**Consultation Response from KC,
Highways Development Management**

2023/93657 The Shears, 201, Halifax Road, Hightown, Liversedge, WF15 6NR

Erection of two detached dwellings with detached garages; alterations to public house with dwelling above to form one dwelling; erection of single and two storey extension to 201a Halifax Road

Date Responded: 20/02/2024.

Proposed Site Plan - 1:200

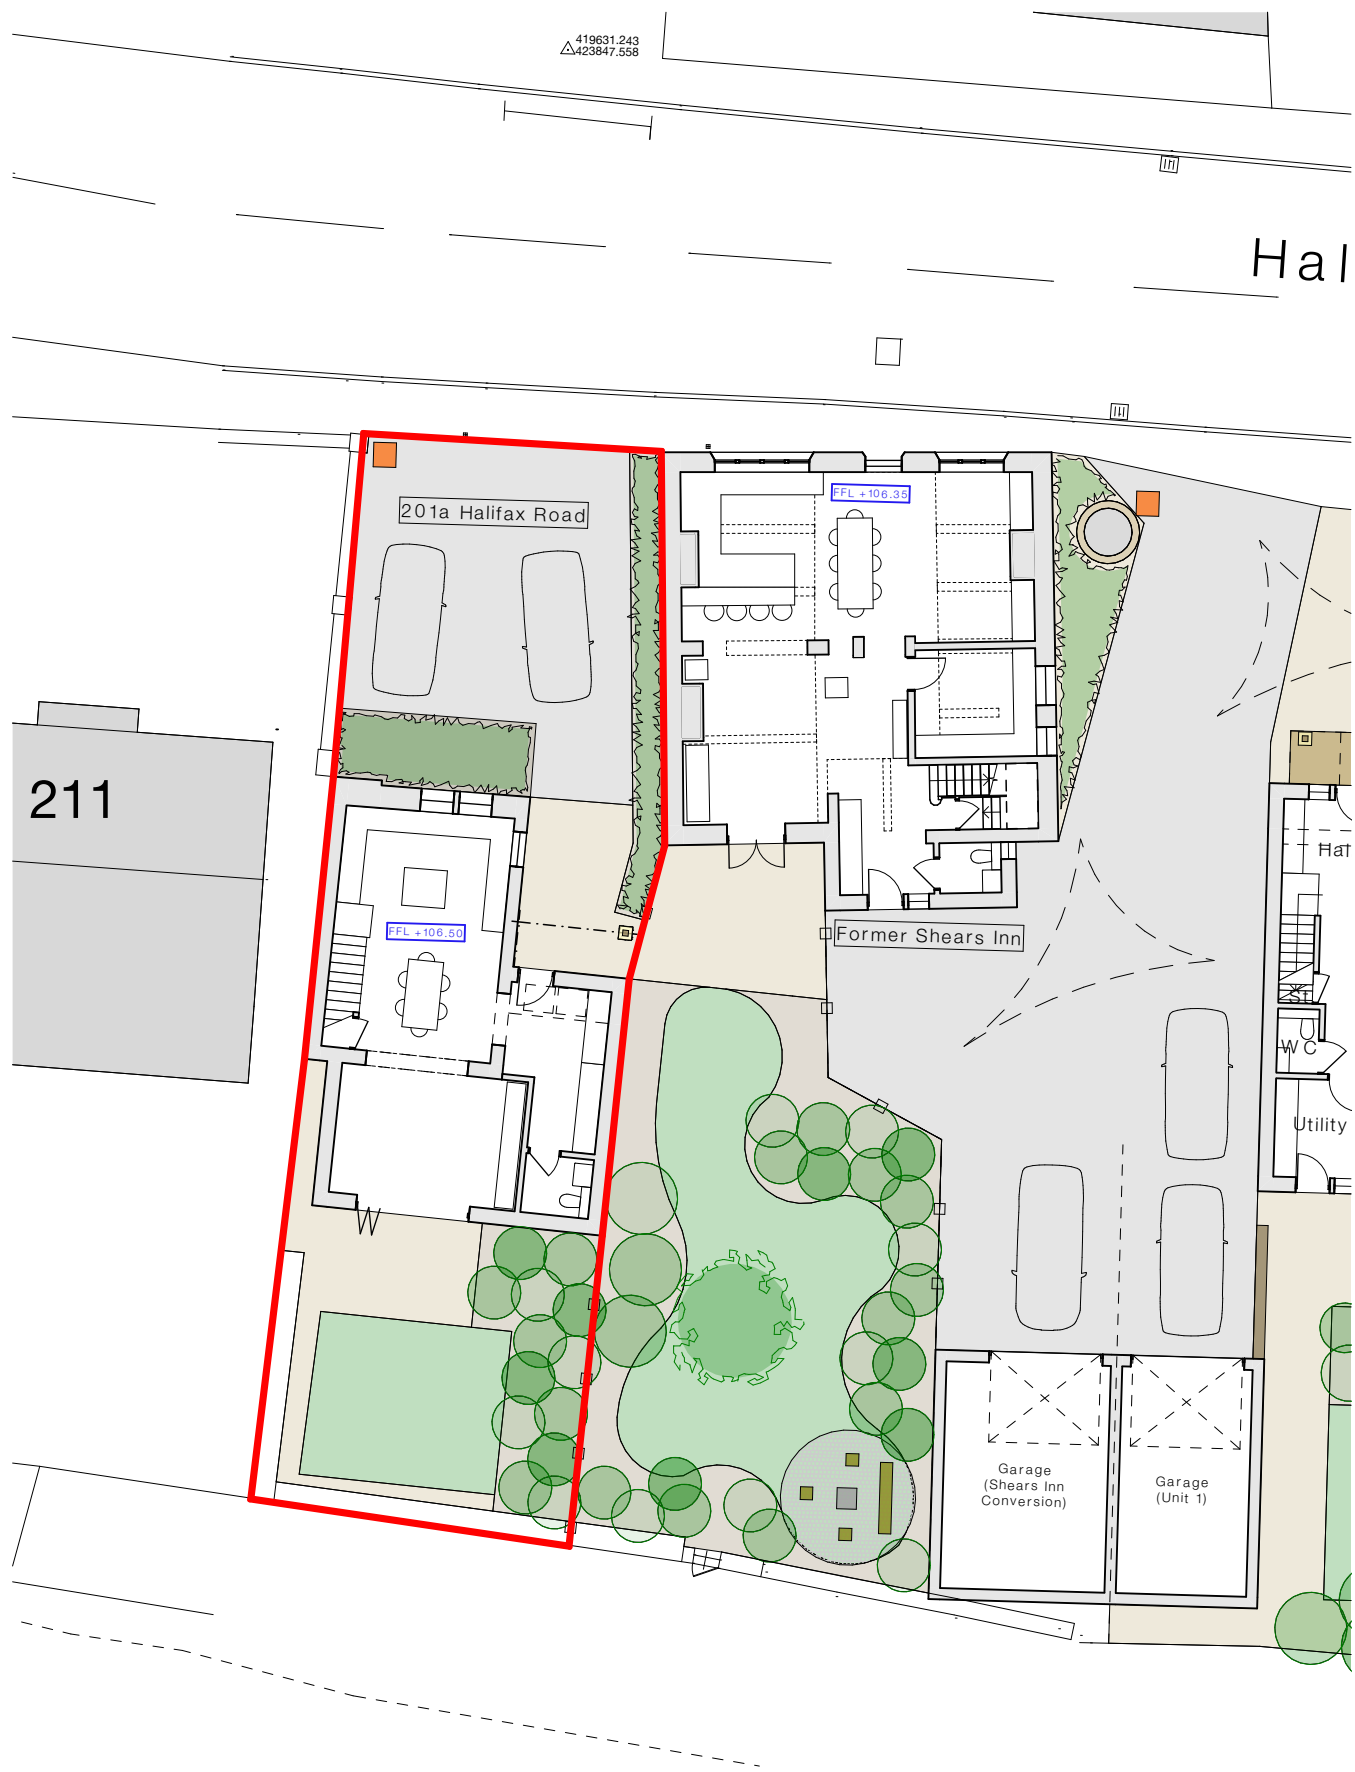
The width of the site access into the development is approximately 3.5m, this should be a minimum of 4.5m to allow two-way vehicle movements in and out of the site.

A revised plan showing a widened access and that visibility splays of 2.4m x 43m can be achieved needs to be provided.

Proposed Ground Floor Site Plan - 1:100

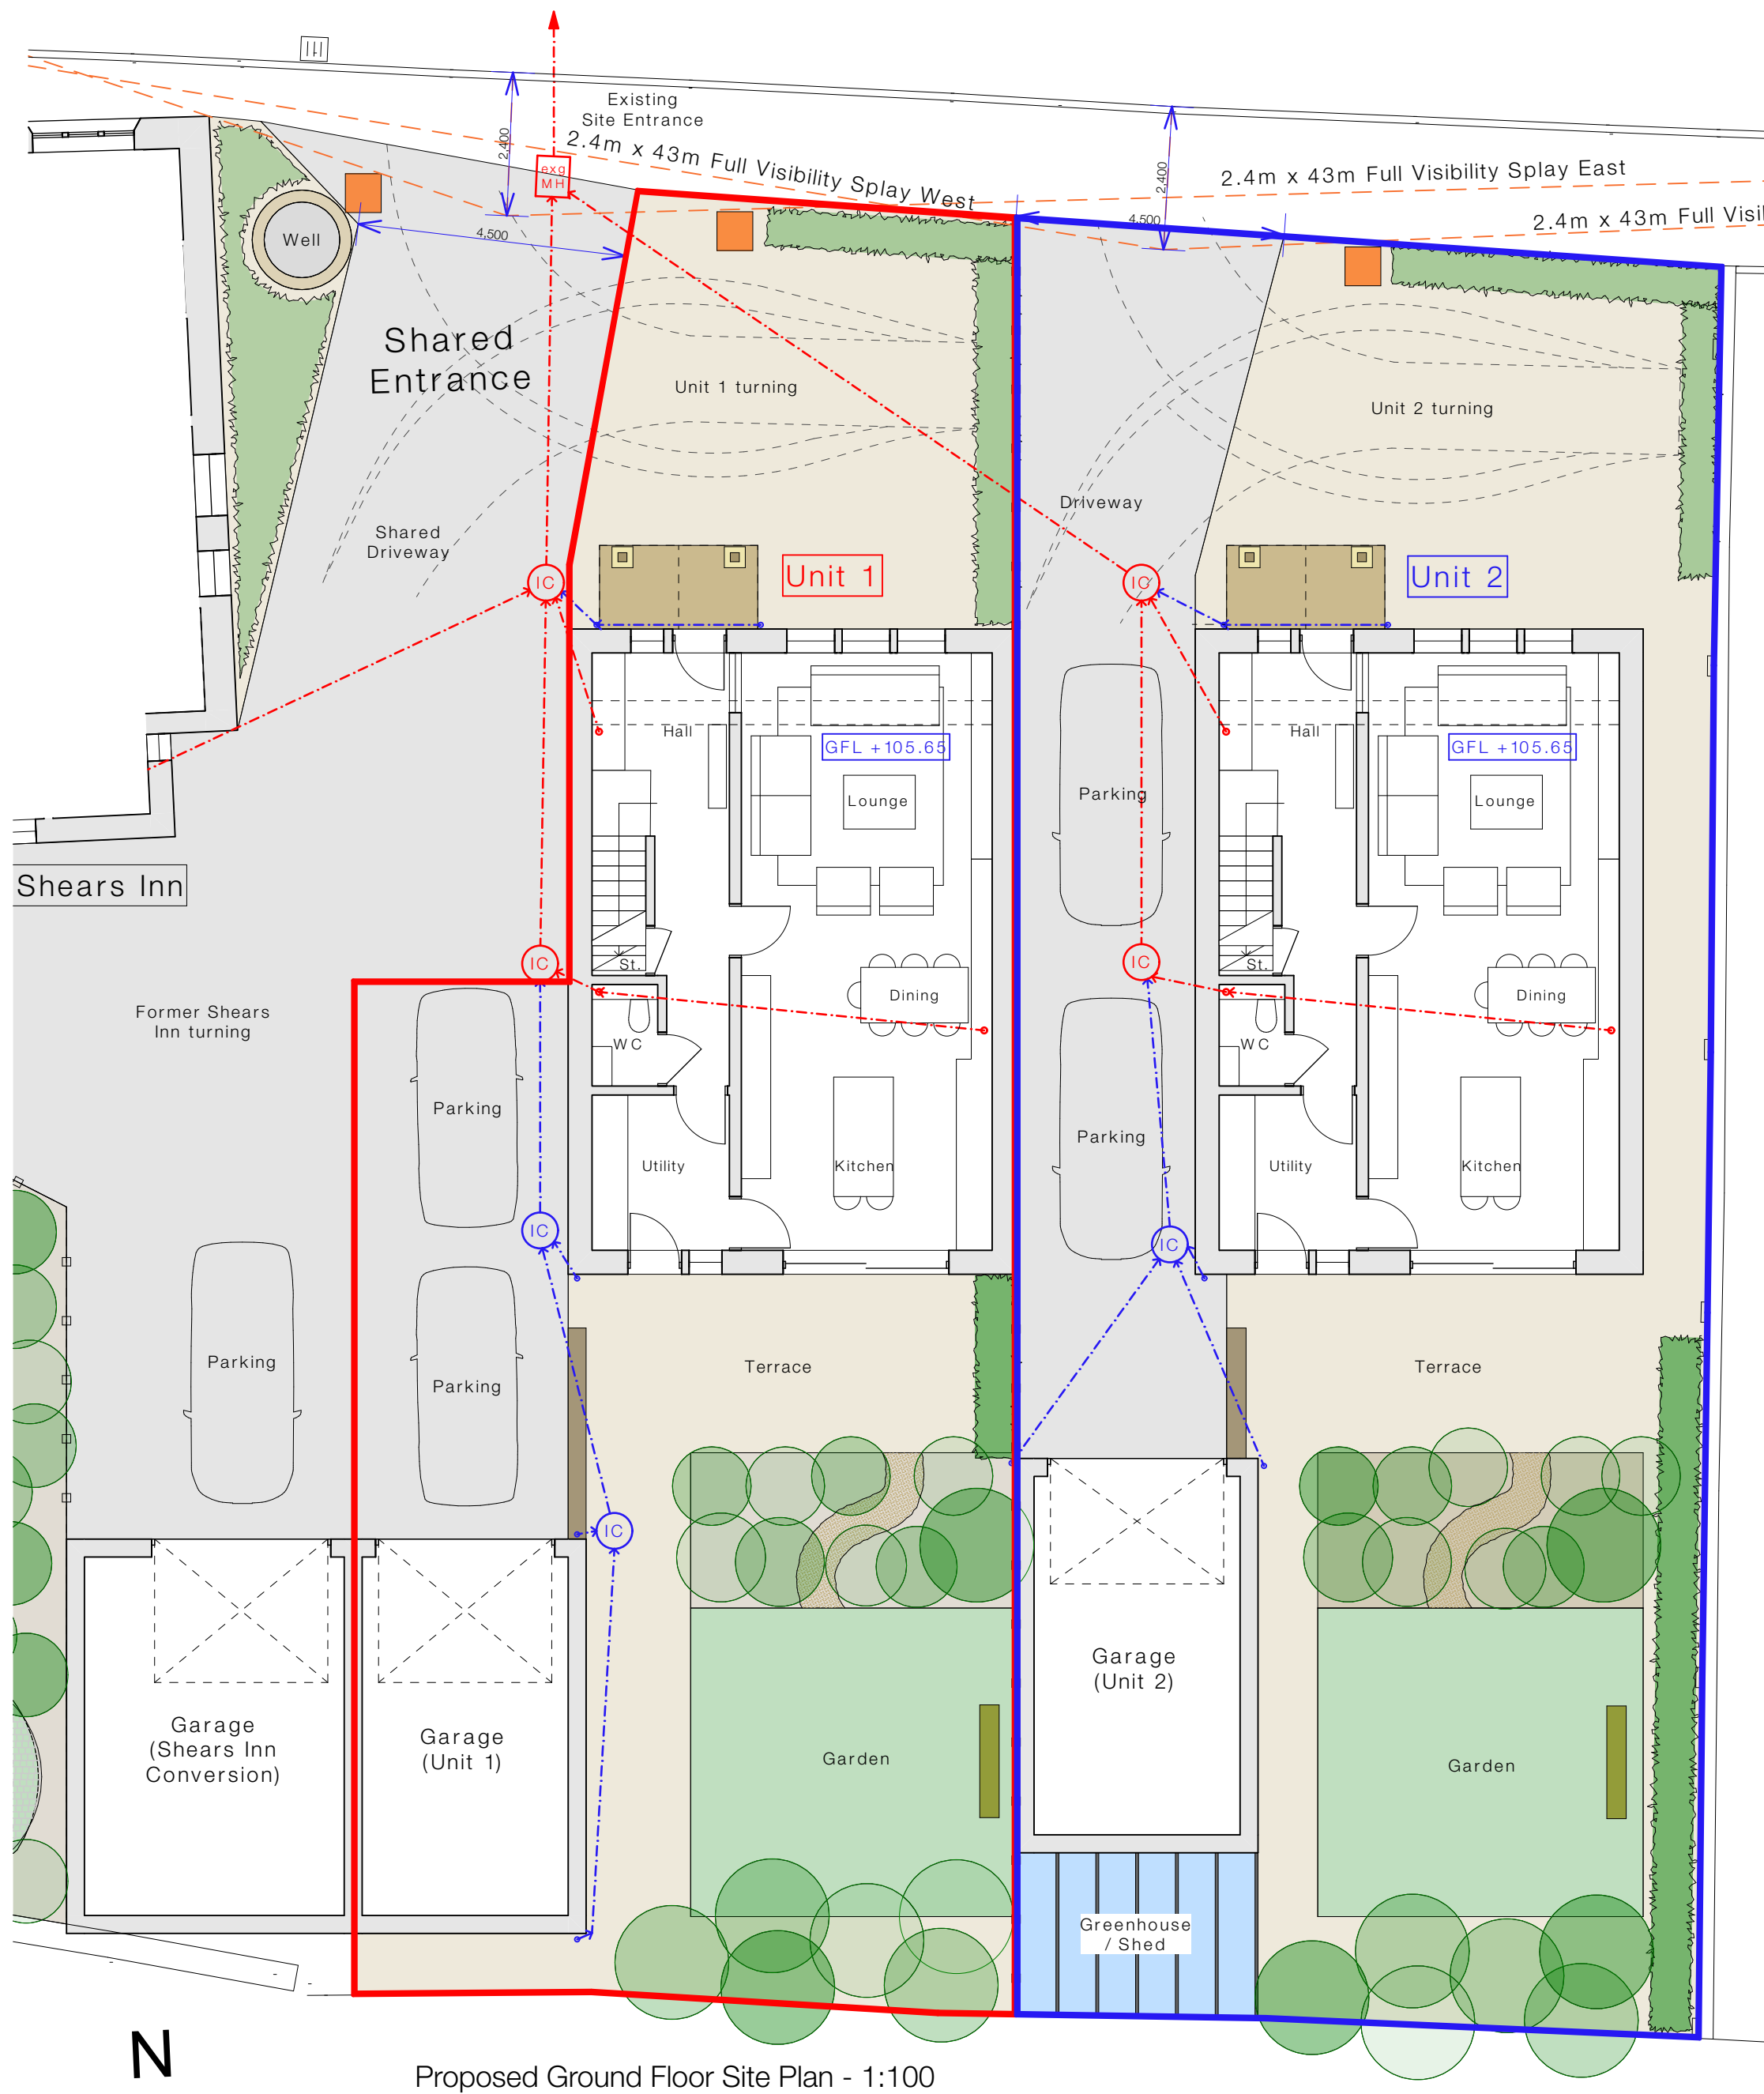
The Kirklees Highway Design Guide states that to ensure residents can access their properties, a private drive serving five dwellings or fewer should be a minimum of 4.5m wide (5.0m wide if there are structures along its initial length for example walls) for the first 5.0m of its length. This will allow vehicles to turn in and turn out.

Manual for Streets states that for a 30mph speed limit sight lines of 2.4m x 43m should be achievable and demonstrated on a suitable plan. Any shortfall of this requirements should be in accordance with 85%ile wet weather speed readings (if below 30 mph).

Any new access on to an A classified road requires that turning within the site is available to ensure that vehicles can enter and egress the site in forward gear.

On site turning has been provided for the public house conversion, but not for the new dwelling (Unit 1).

A revised plan showing on site turning for the new dwelling (Unit 1) needs to be provided.

Manual for Streets states that for a 30mph speed limit sight lines of 2.4m x 43m should be achievable and demonstrated on a suitable plan. Any shortfall of this requirements should be in accordance with 85%ile wet weather speed readings (if below 30 mph).

A revised plan showing that visibility splays of 2.4m x 43m can be achieved needs to be provided.

Any new access on to an A classified road requires that turning within the site is available to ensure that vehicles can enter and egress the site in forward gear.

A revised plan showing on site turning for the new dwelling (Unit 2) needs to be provided.
